Re: Request for further information BR/272/20/HH

BLOCK PLAN 1:500

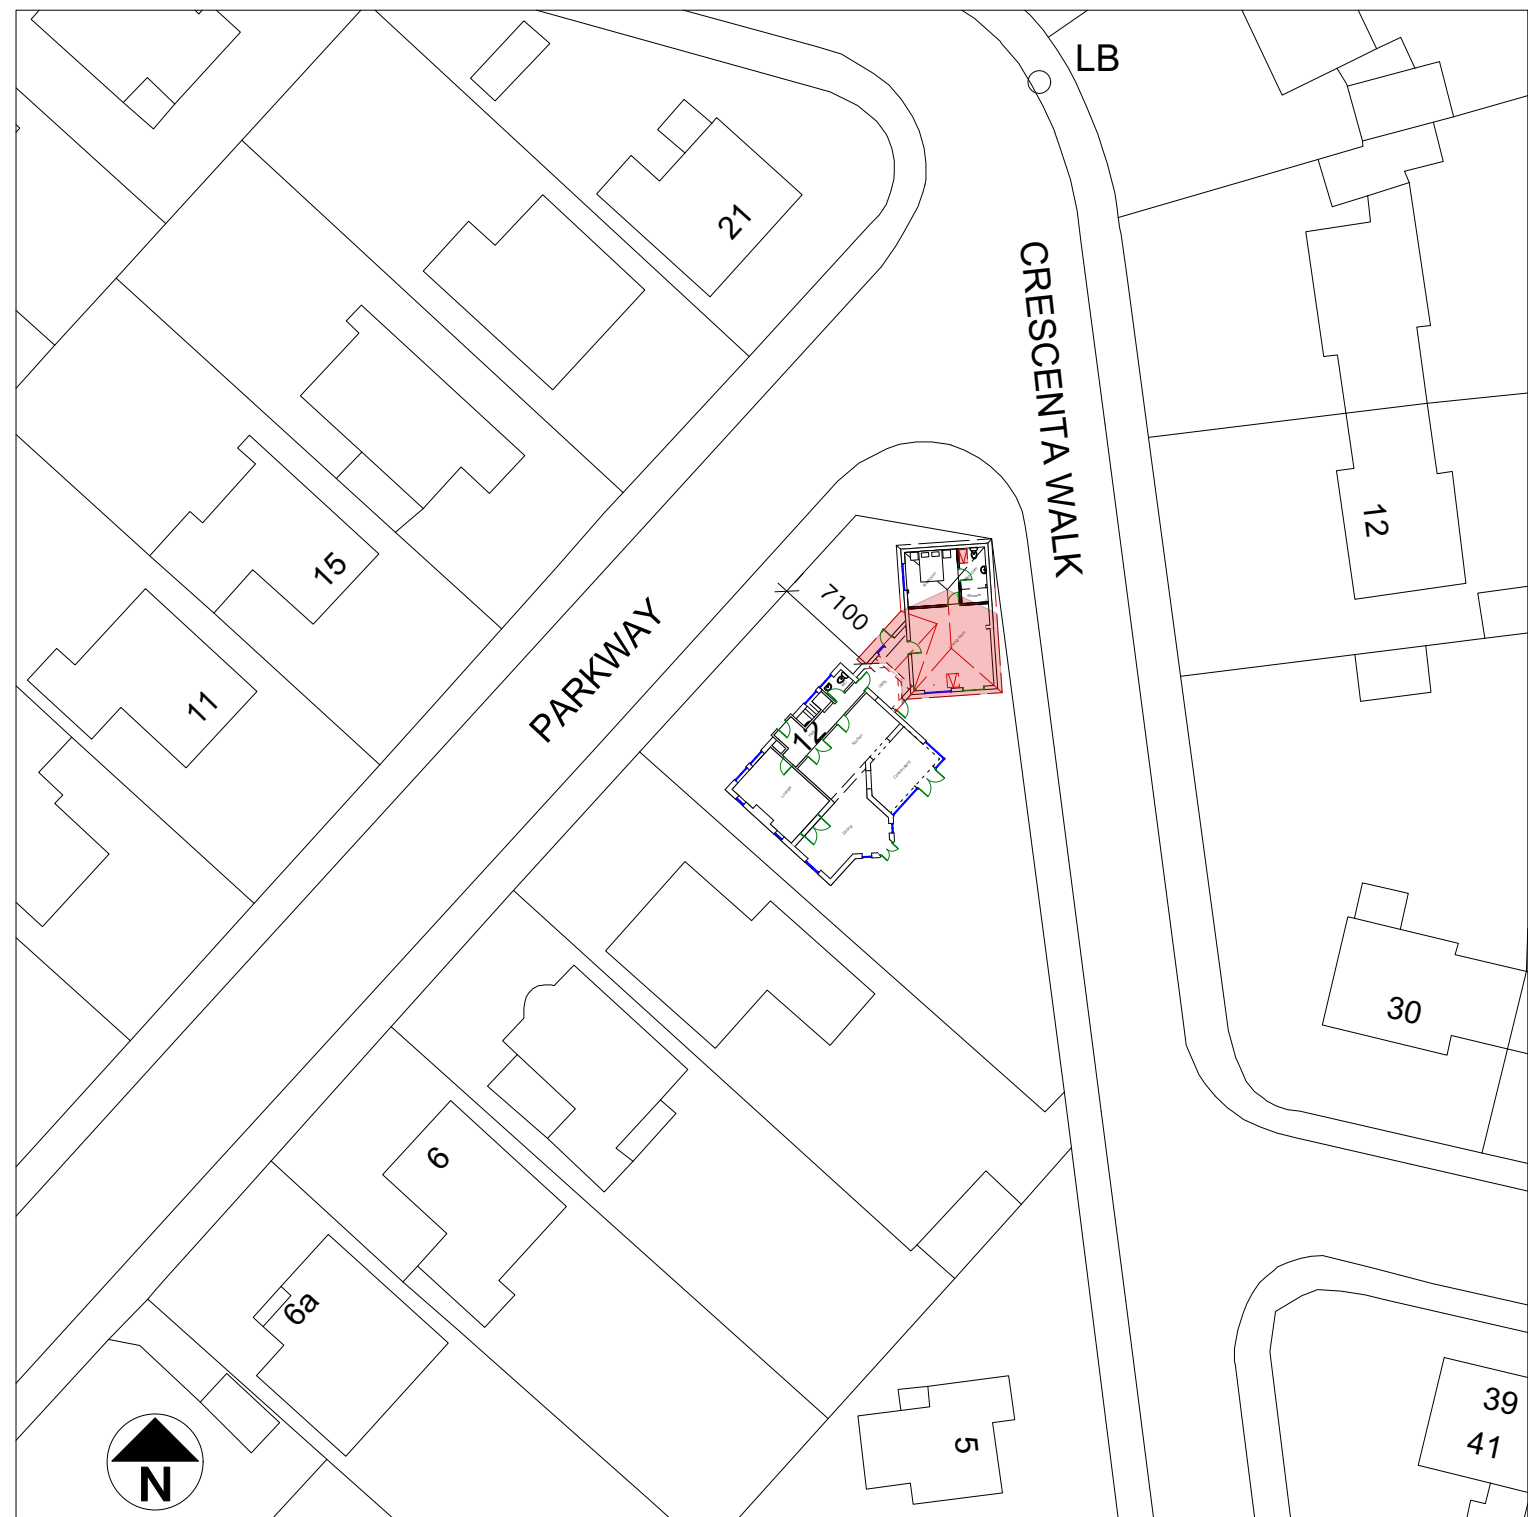
This application is currently invalid as the block plan requires dimensions from the proposed extension to all site boundaries. Please amend to include the other boundaries.

Try this, revised Block Plan please confirm.
